APPLICATION NO : 2010/0168

DESCRIPTION: Erection of single storey front extension to dwelling

LOCATION: 5 Schofield drive, Darfield, Barnsley, South Yorkshire, S73 9AX

Further to our recent conversation regarding the above address, I enclose amended drawings as requested.

PROPOSED ELEVATIONS

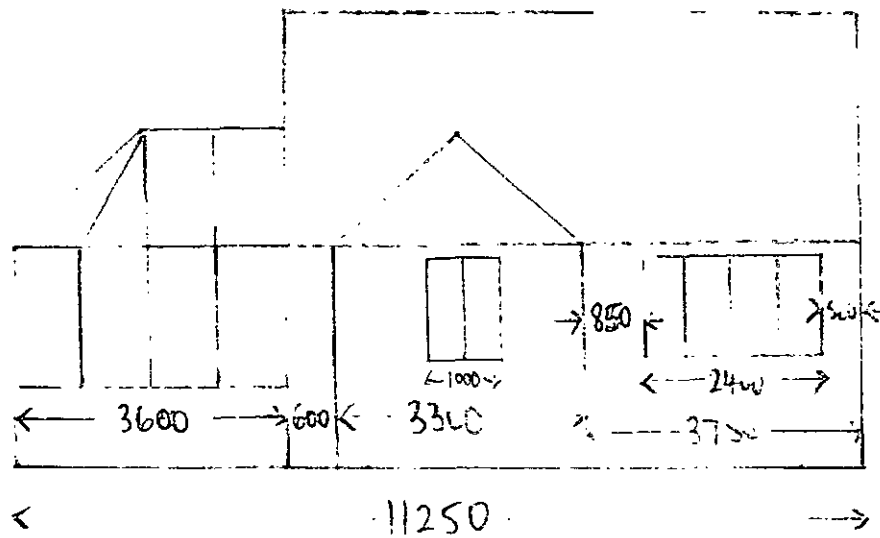
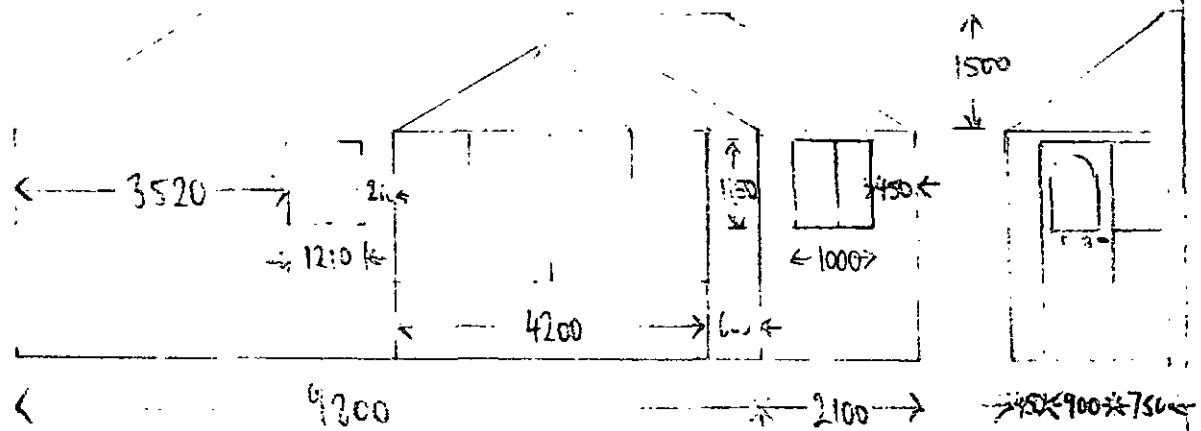
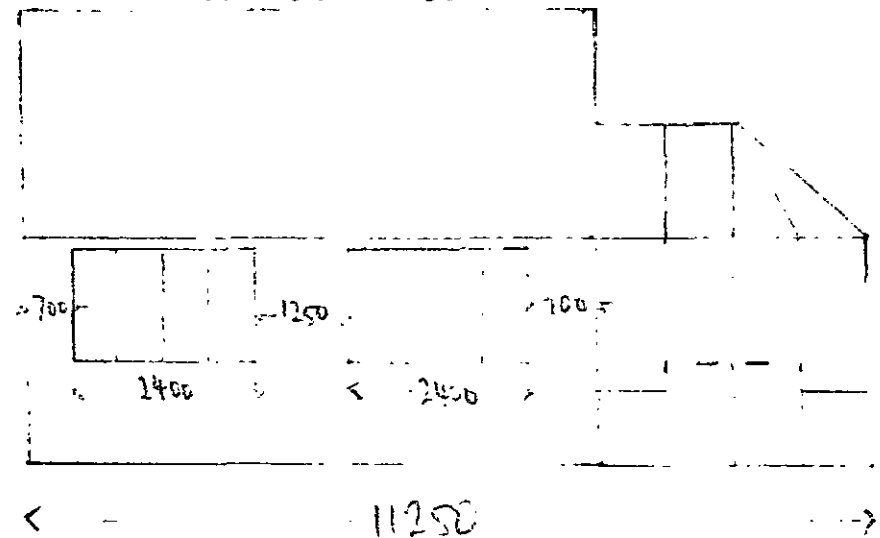
I have put a 1000mm width window to the front elevation and made the window on the left hand side elevation the same size.
